Recommendation Report for Planning Permission for Works or Extension to a Dwelling

REF NO: FP/110/19/HH

LOCATION: 65 Wroxham Way  
Felpham  
PO22 8ES

PROPOSAL: Single storey front & rear extensions.

FRONT ELEVATION 1:100.

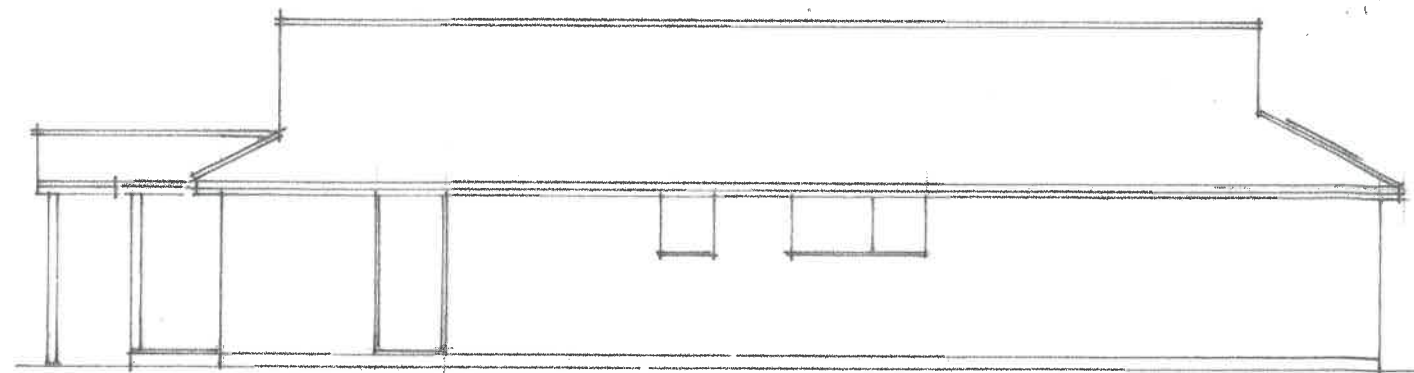
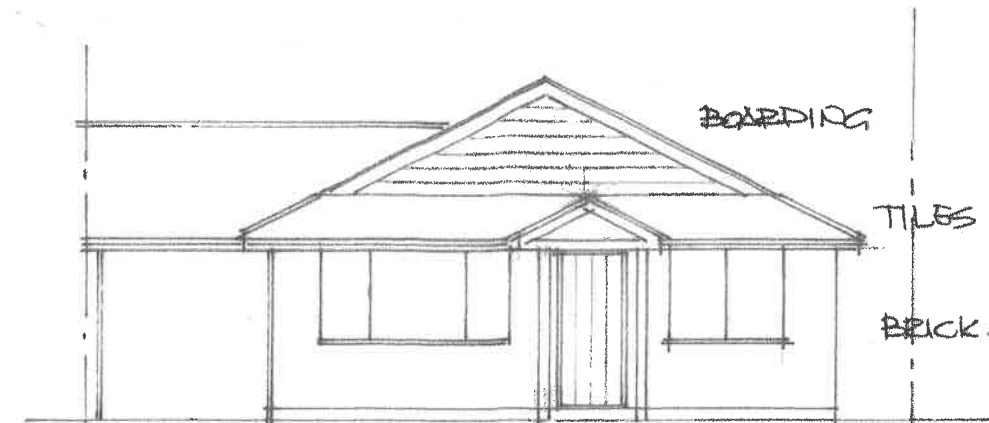
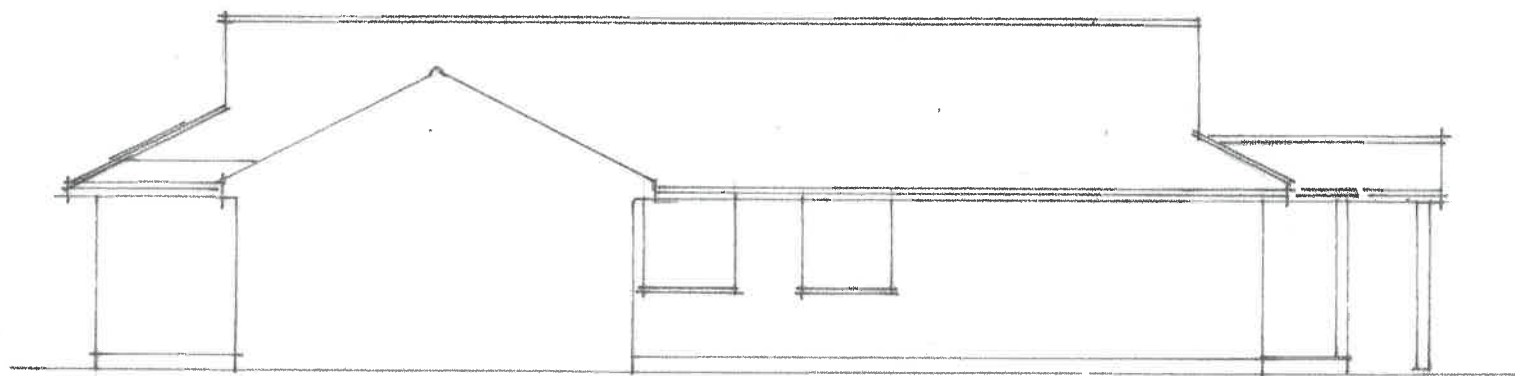
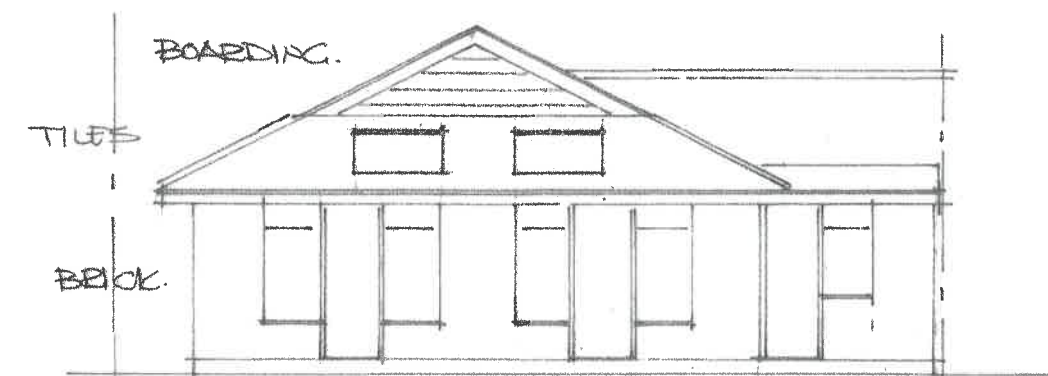
The proposed front extension given its location will be visible from the street scene, it will therefore it will have an impact on the character of the host dwelling or the street scene, however it is deemed to be subservient to the host dwelling and would not result in any adverse impact on the spatial pattern or character of the area and would therefore accord with the policies D DM1 and D DM4 of the Arun Local Plan.

Although this application will be the first in the area to have a pitched roof to the front of the dwelling on an extension it is not deemed to be detrimental to the character of the area or the spatial pattern of the road.

PLAN 1:100.

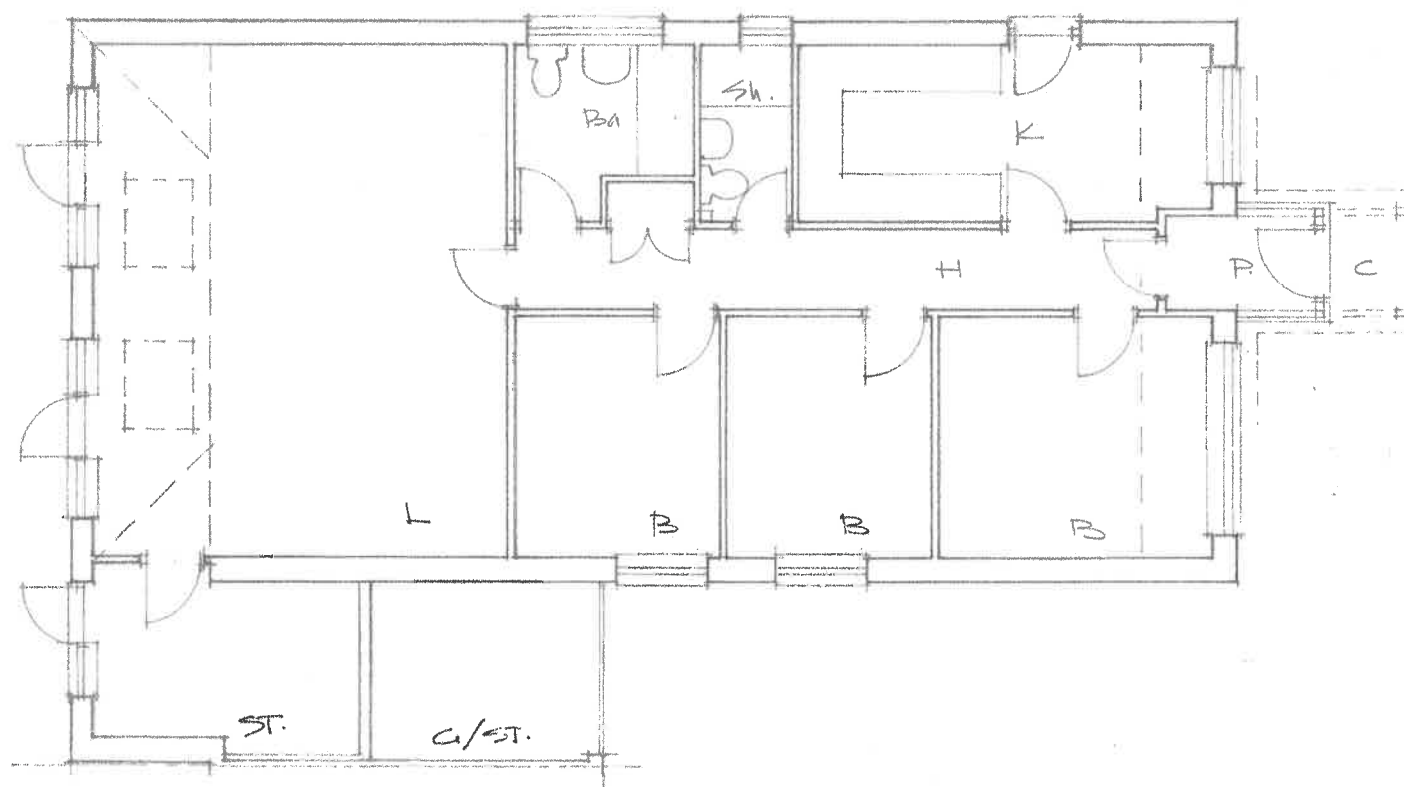
The applicant seeks planning permission for the construction of a rear and front extension to the established dwelling. The proposed rear extension will measure approximately 9.8m wide, 2.4m in depth and be built to the proposed height of 3.2m and the eaves height of 2.2m. The proposed front extension will be measuring 3.75m in width, 0.5m in depth and to a proposed height of 2.8m and at the eaves 2.2m. the proposed front extension has a porch protruding a further 1.2m with a width of 0.9m.

The proposed rear extension will be located approximately 10.3m from the northern boundary and 1.05m from the eastern boundary. The extension to the front of the property will be approximately 6m from the southern boundary.
